**Consultation Response from KC Environmental Health – Pollution & Noise Control
2020/90682 Croft Medical Centre, Cobcroft Road, Fartown, Huddersfield, HD2 2RU**

Discharge conditions 5 (ventilation) and 6 (boundary treatment) on previous permission 2014/90774 for erection of 2 storey medical centre with integral pharmacy and parking

Date Responded:
30th March 2020

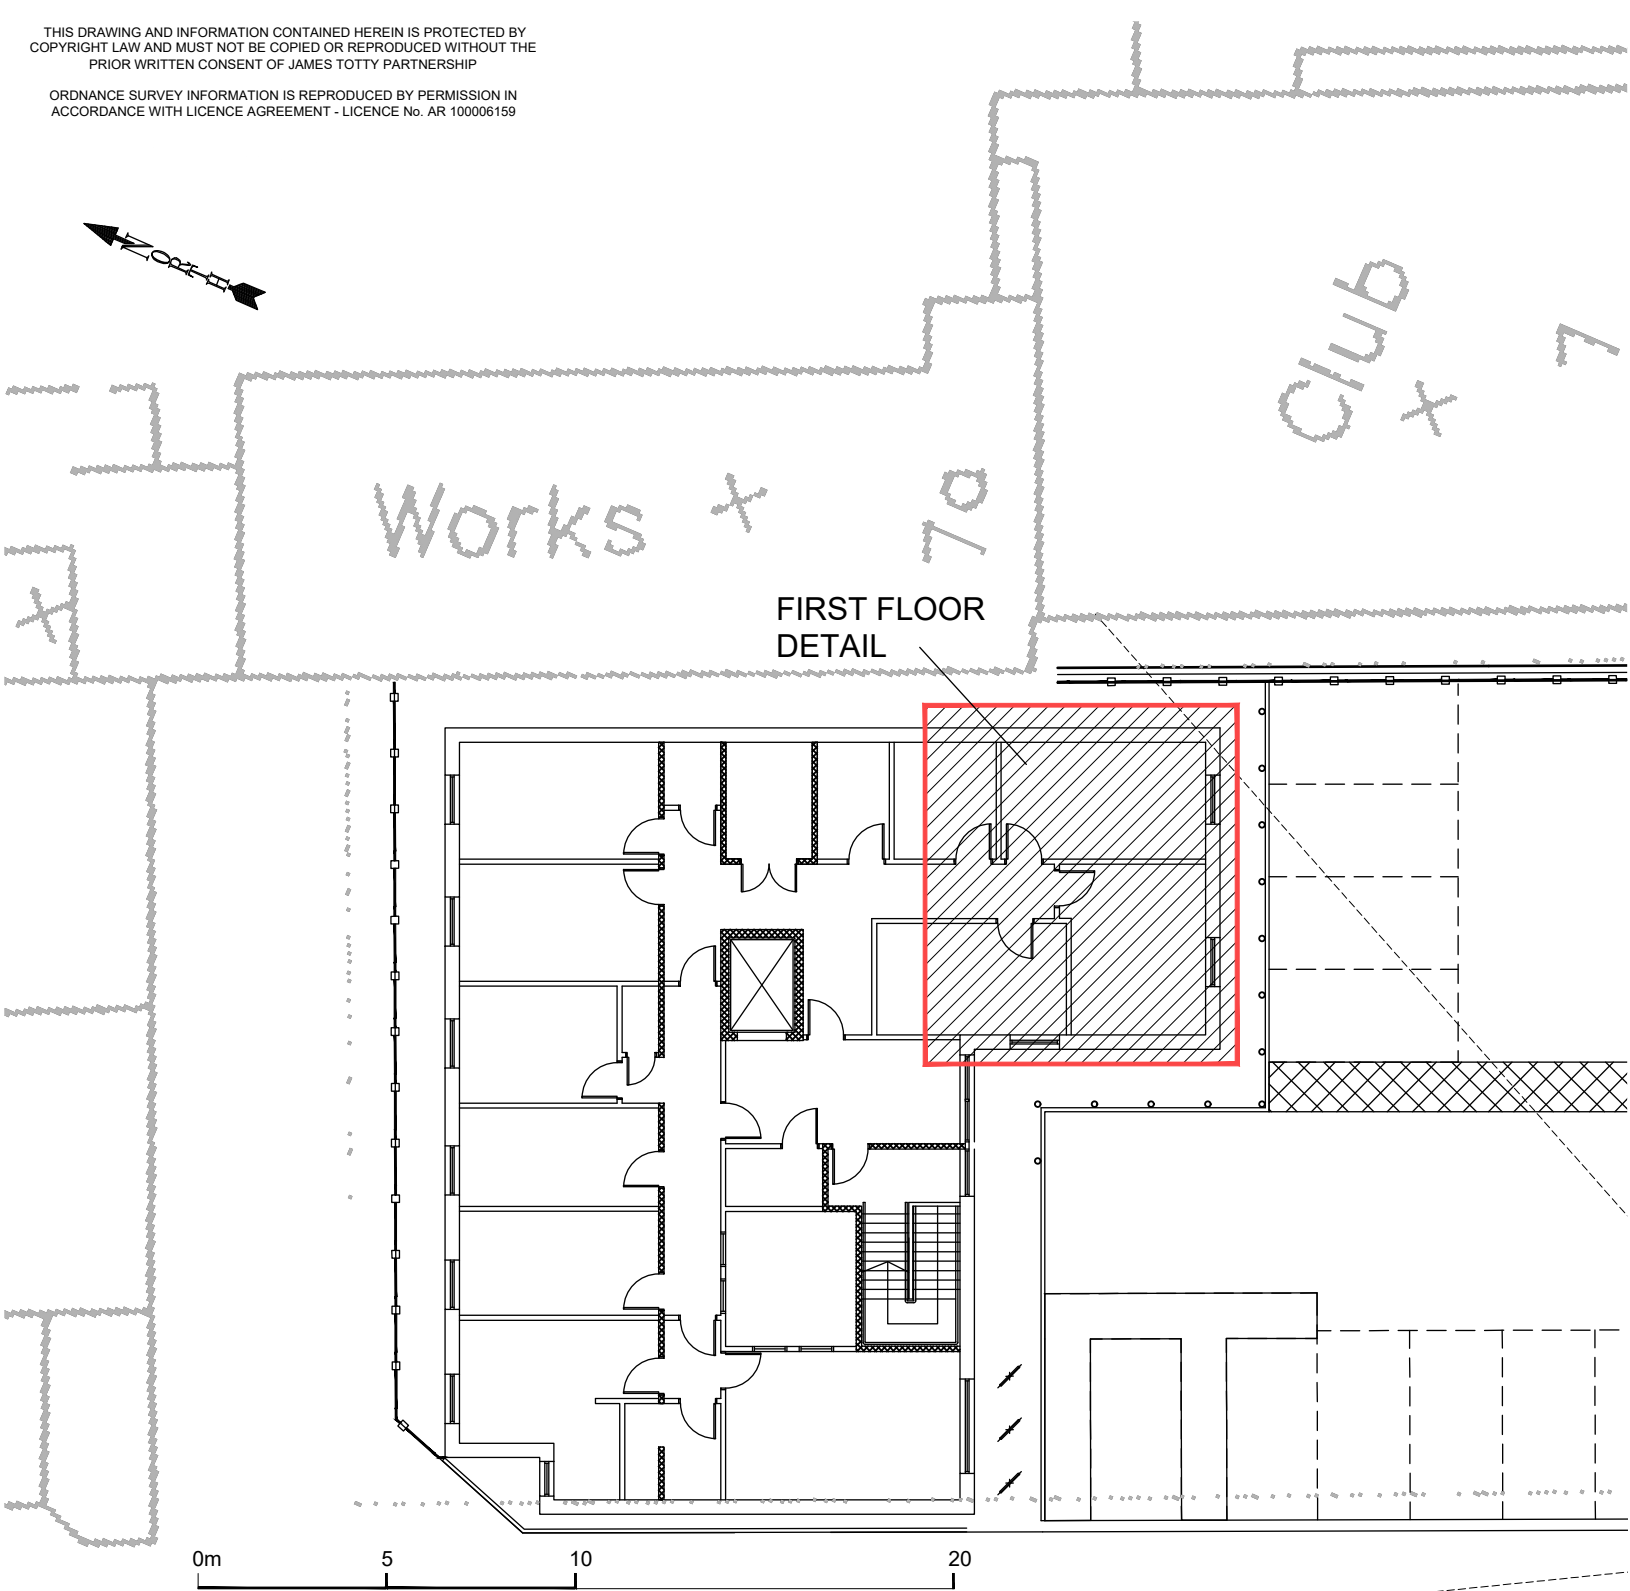
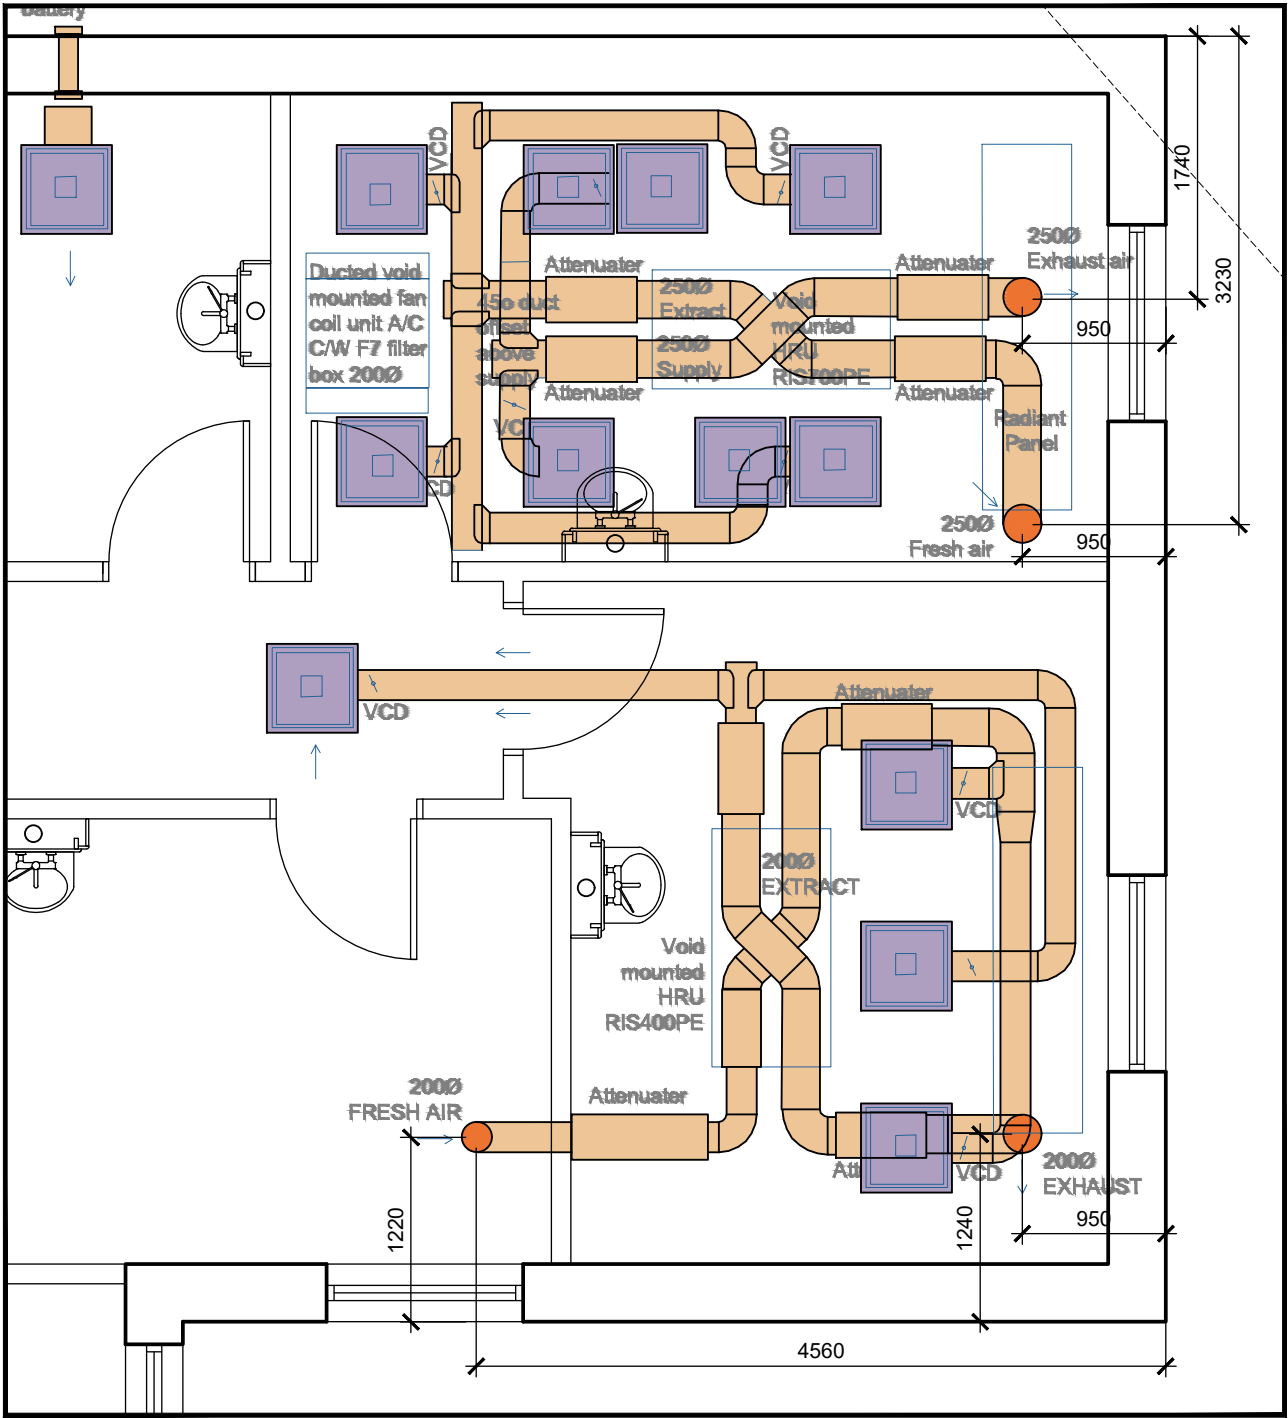
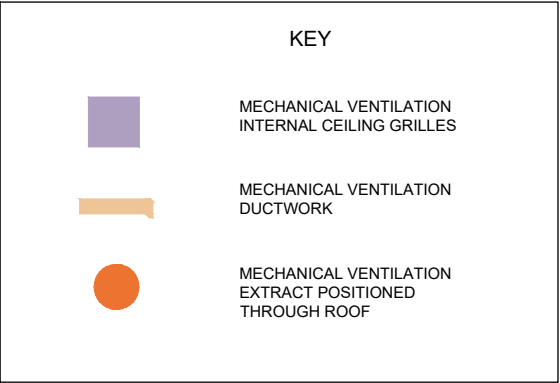
Having reviewed the ventilation plans and the accompanying acoustic report provided by Acoustic Design Technology Limited dated 20/02/2020. This assessment determines that the levels associated with the proposed ventilation:

"are at least 13 dB below the otherwise prevailing background levels".

I can confirm that this satisfies the requirements of condition 5, and therefore condition 5 can now be discharged
